Public Review Correction Response Memo

Subject: Public Review Comments Responses (Rev 1)
Permit No: 2103-051
Address: 3018 69th Ave SE
Mercer Island, WA
To: City of Mercer Island
Reviewer: Lauren Anderson

**A2.01**

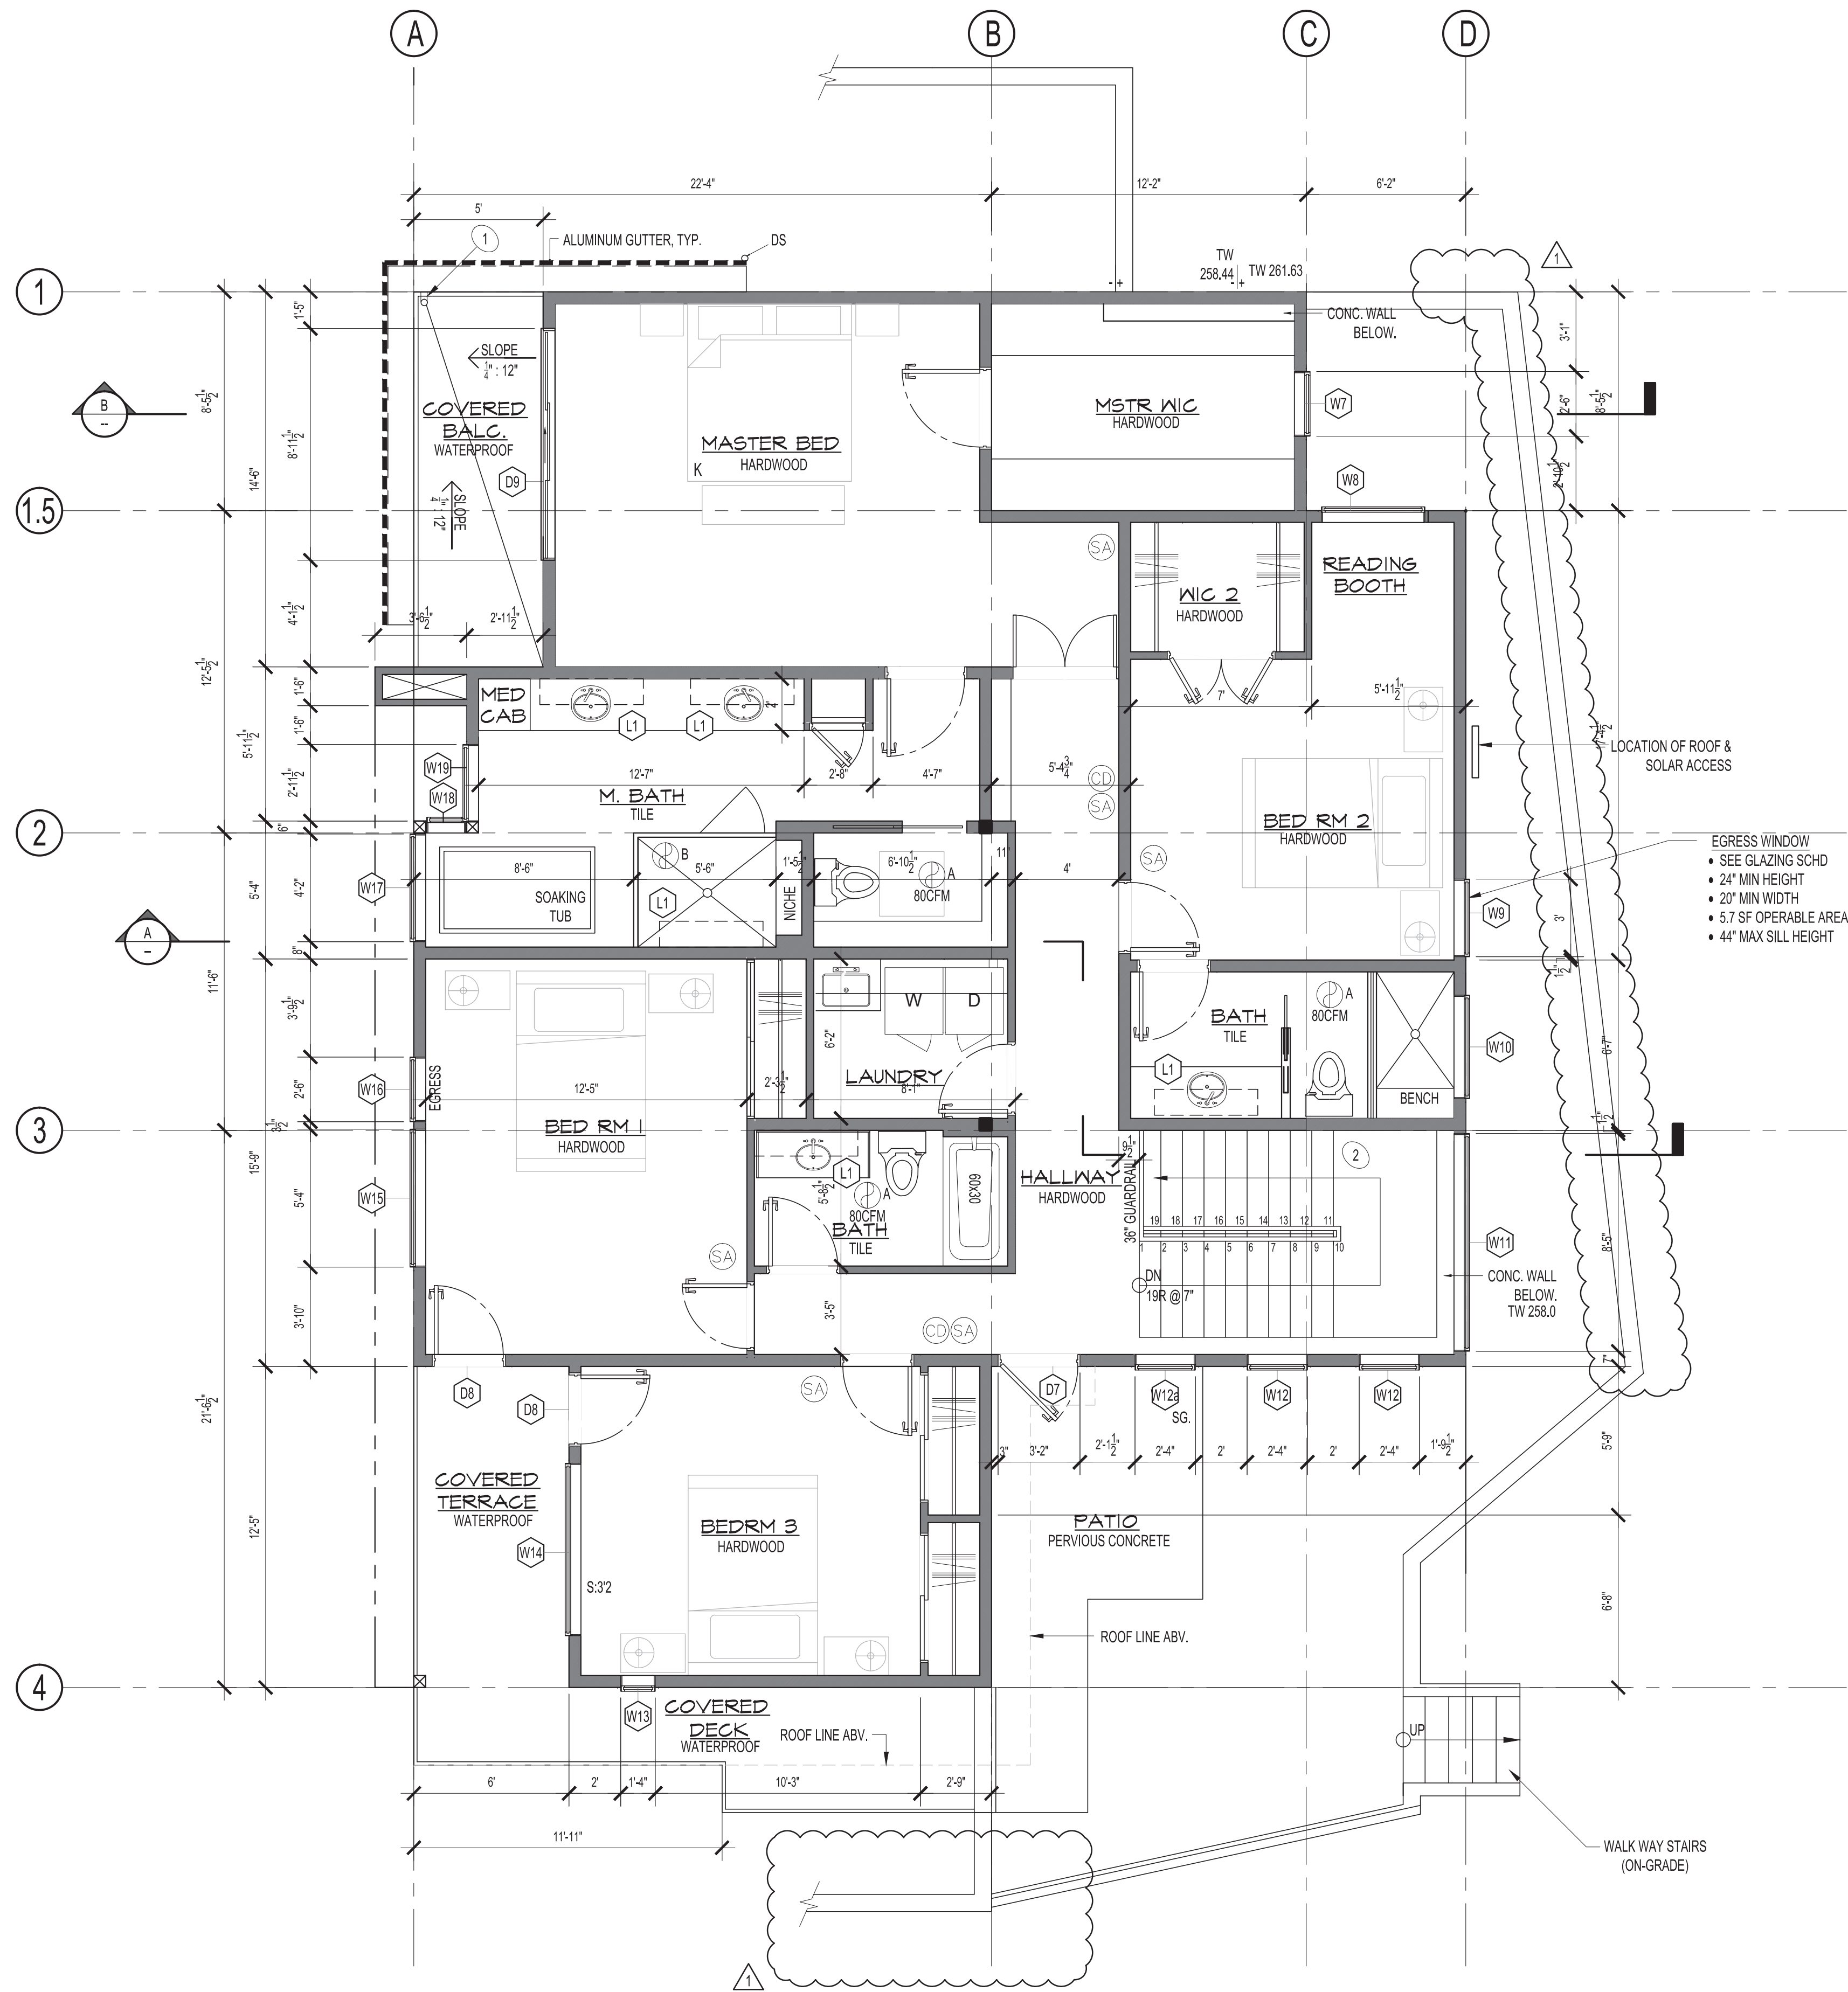
1. Fencing – I didn't see any description of any fencing in the plans and wanted to learn what their plans are for that, if any.
2. AC condenser location – I didn't see any provision for the placement of any condensers that they are going to put in (assuming they are installing AC). Based on the location of the mechanical room, it would appear to be on the south side of the structure but wanted to know what the plan is.

#2 – The condensor location has been added and located next to the north wall on main floor and can be found on sheet A2.01 keyplan #2.
